Rezoning Transportation Analysis
Petition Number: Insert Zoning Petition #2021-207
General Location Identifier: 15902801

Revision Log:	Date	Description
	01/21/2022	First Review (WB)
	02/21/2022	Second Review (WB)
	03/16/2022	Third Review (WB)

SITE PLAN

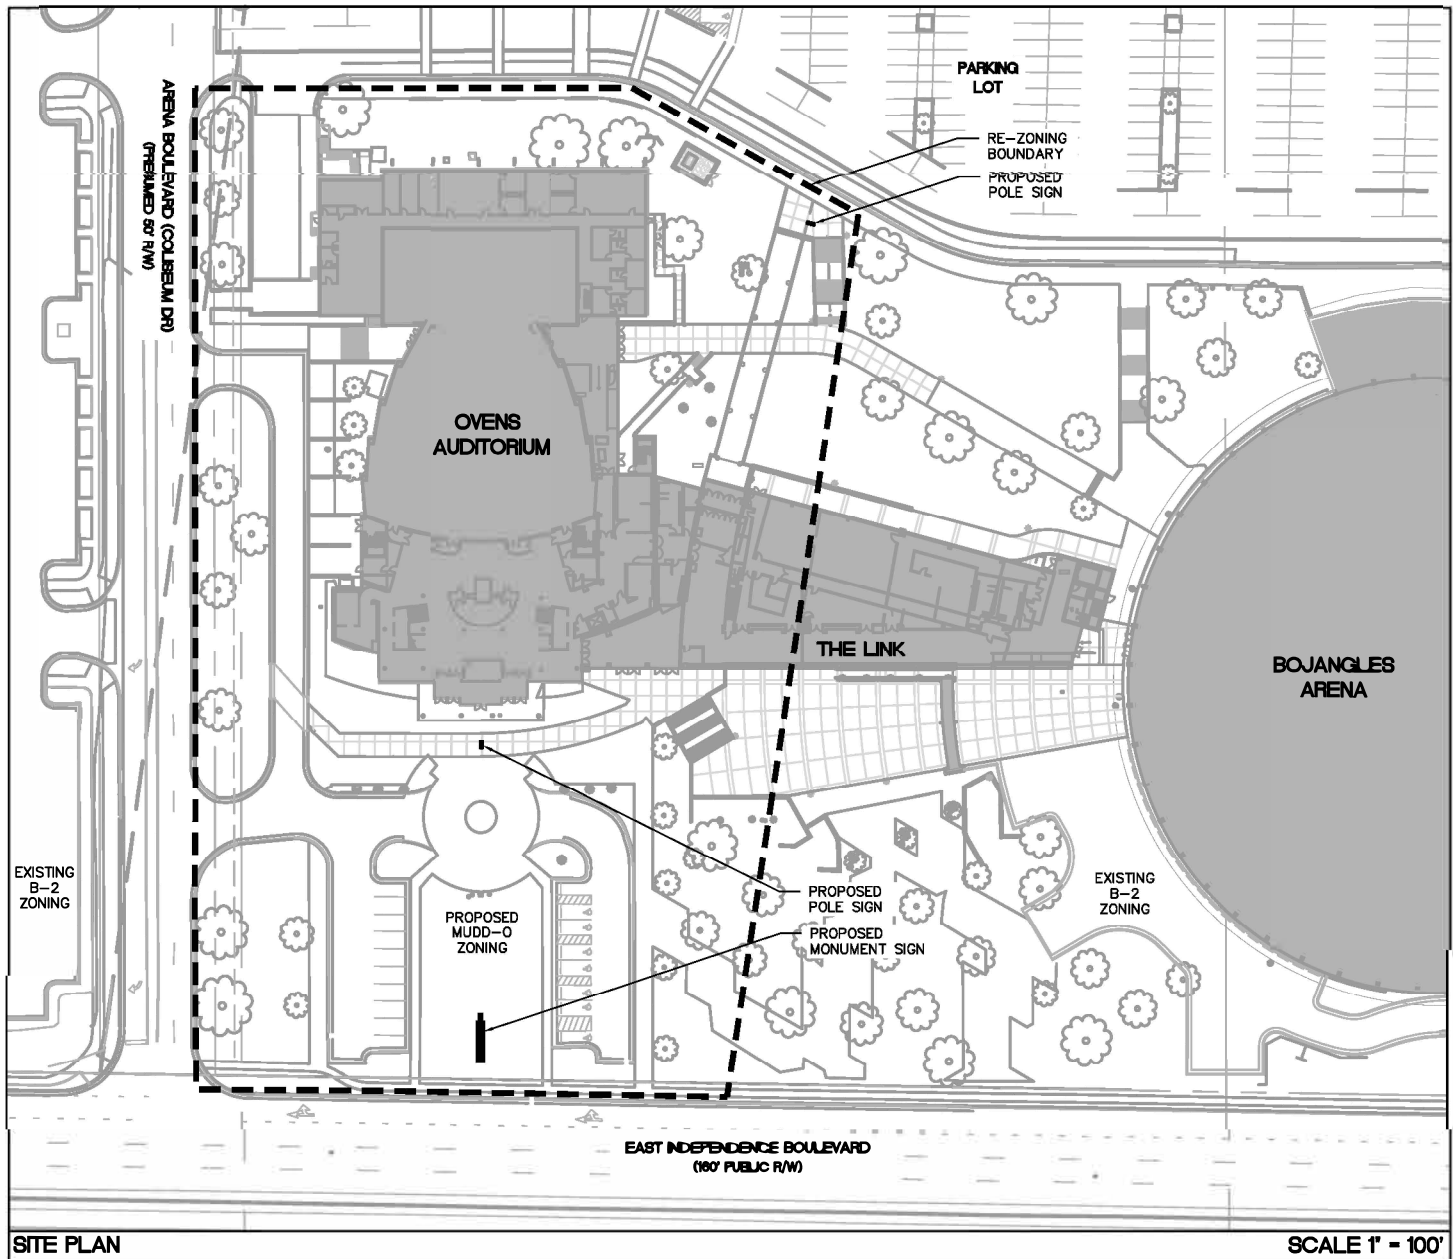
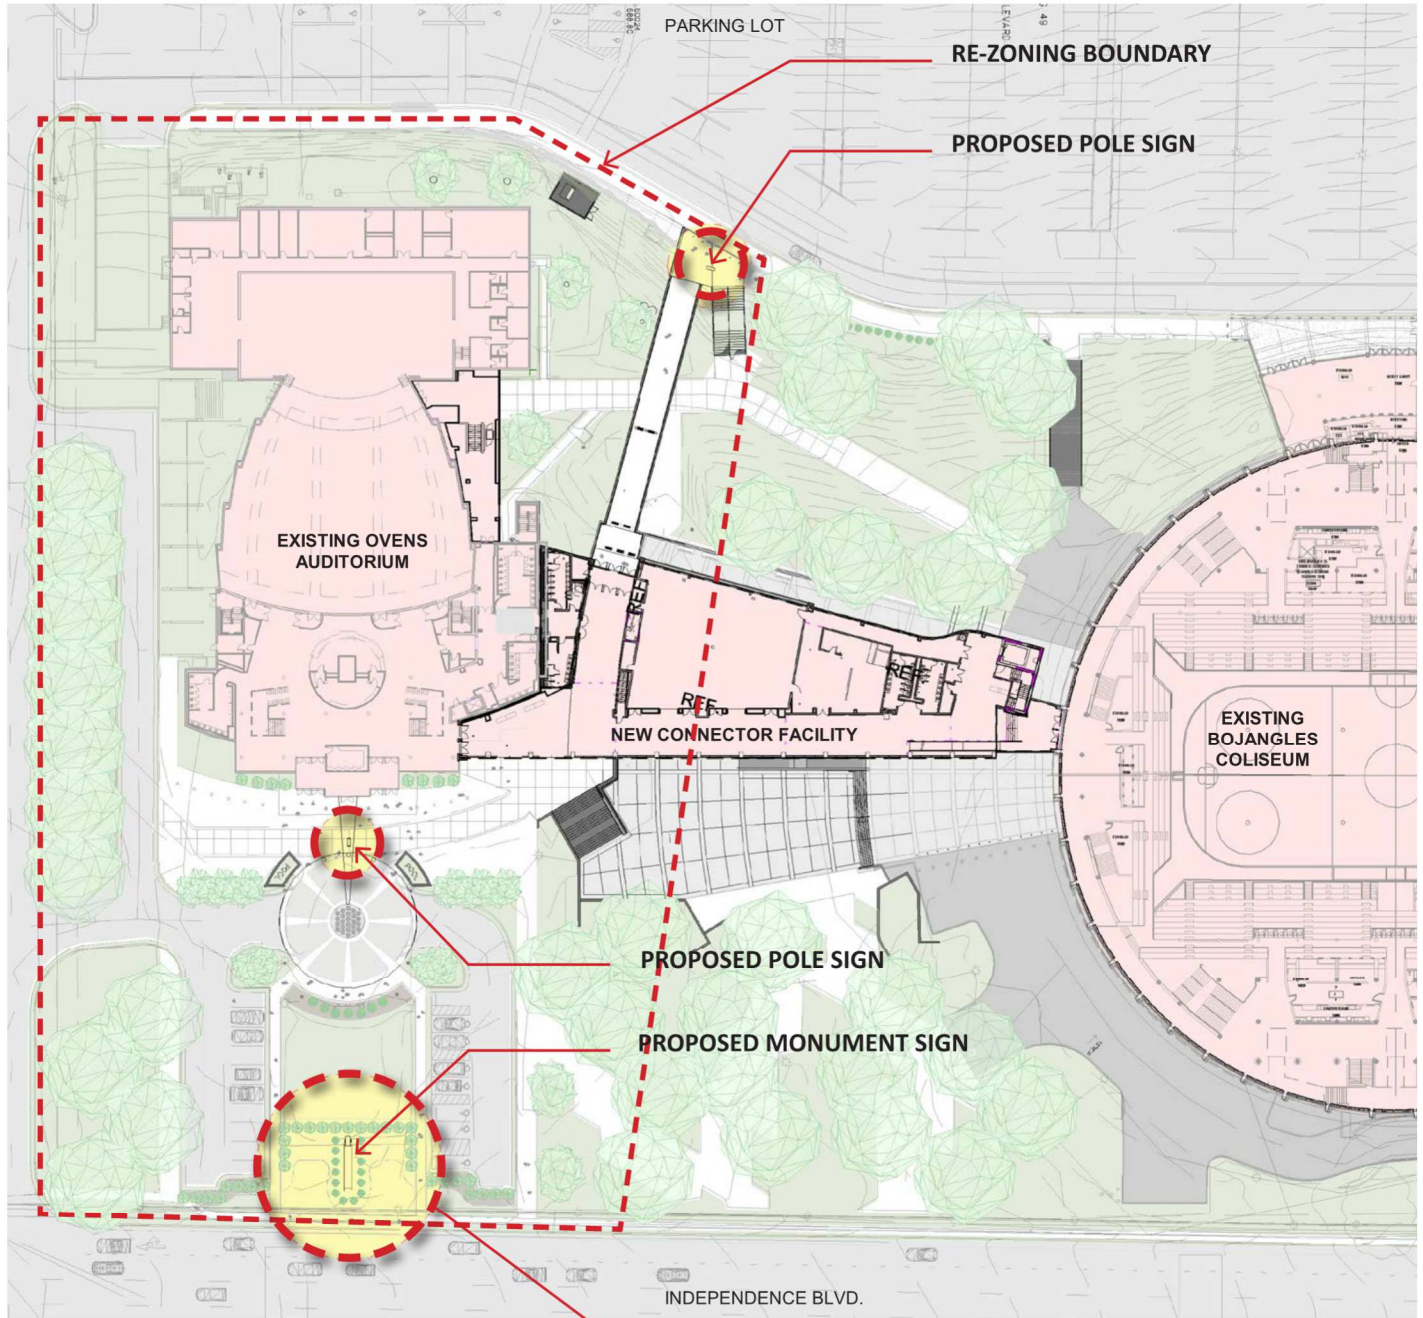
1. ~~**Curblines:** The proposed zoning district has a setback measured from back of the existing or proposed future curblines.~~
 - a. ~~**Independence Blvd:** The future location of curb and gutter is in its existing location.~~
 - b. ~~**Coliseum Drive:** The future location of curb and gutter is in its existing location.~~

~~Label and dimension the curb and gutter from the centerline for each road on the site plan.~~

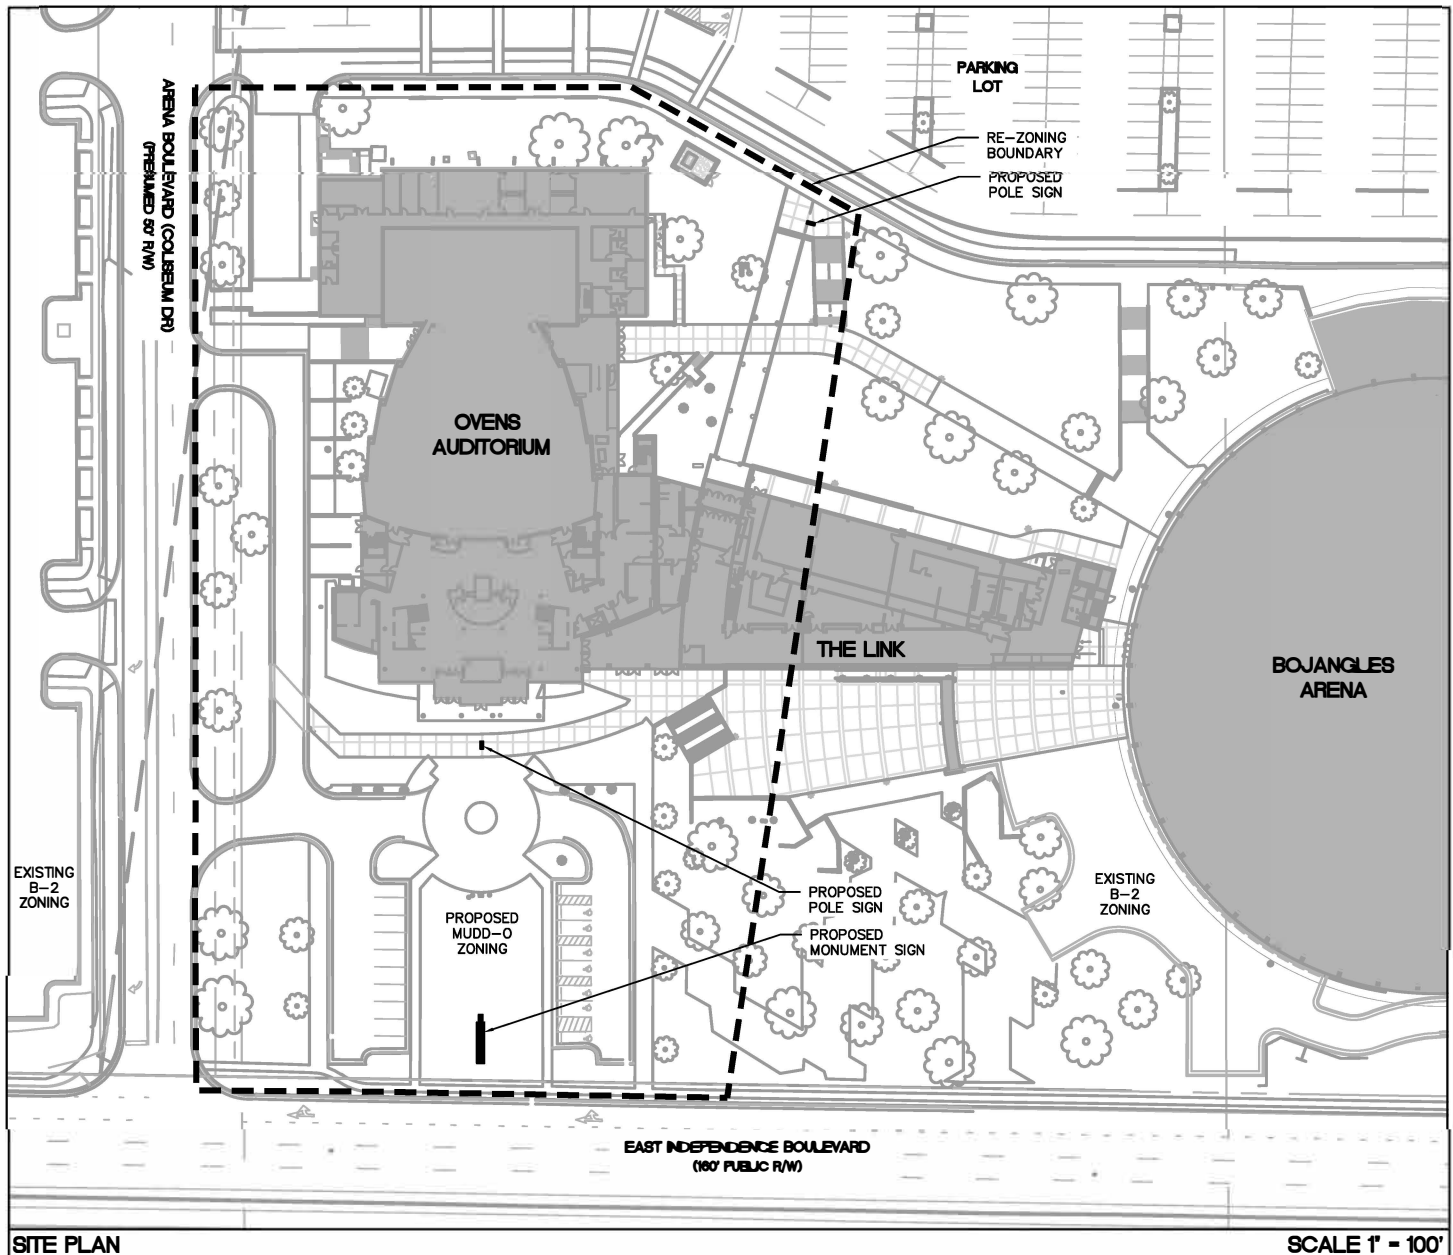
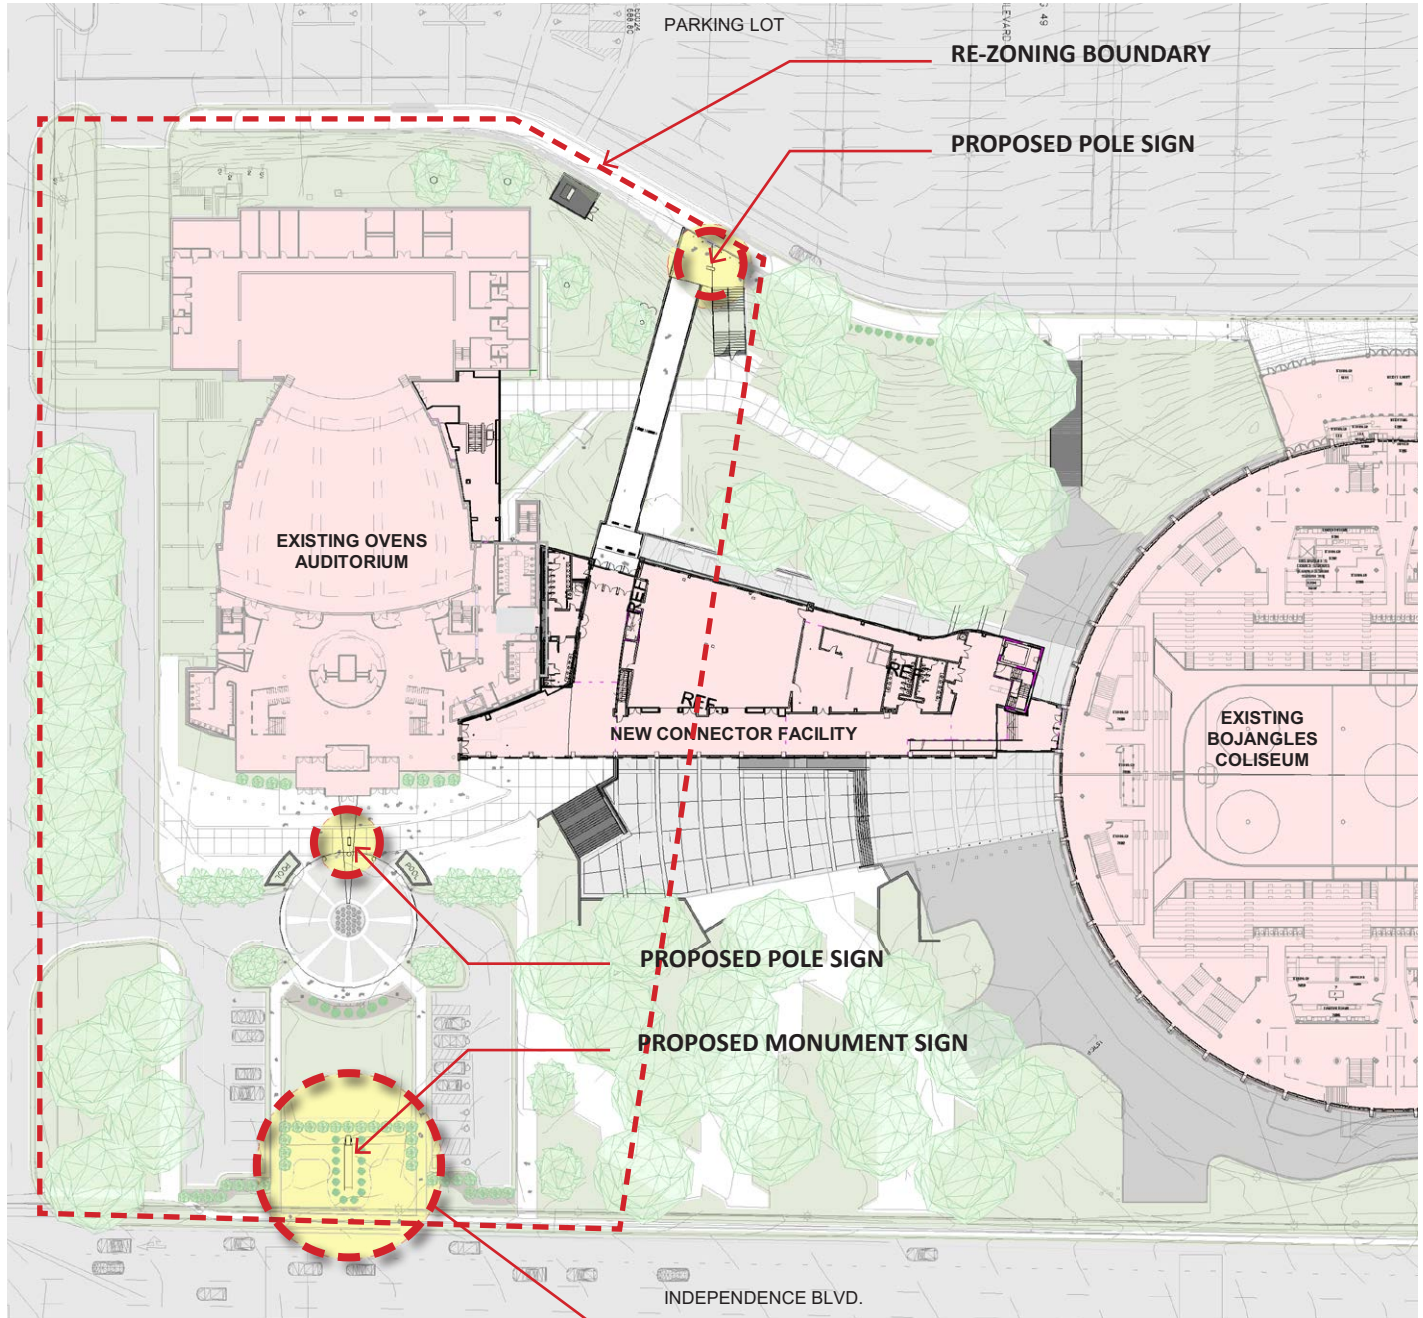
3. ~~Add a conditional note to commit to obtaining a permit with the NCDOT Outdoor Advertising Unit prior to construction. (Mason Thompson is the NCDOT contact).~~
4. ~~Add the following conditional note, "All public roadway improvements will be subject to the standards and criteria of CDOT and NCDOT, as applicable, to the roadway improvements within their respective road system authority. It is understood that such improvements may be undertaken by the Petitioner on its own or in conjunction with other development or roadway projects taking place within the broad central Mecklenburg area, by way of a private/public partnership effort or other public sector project support."~~
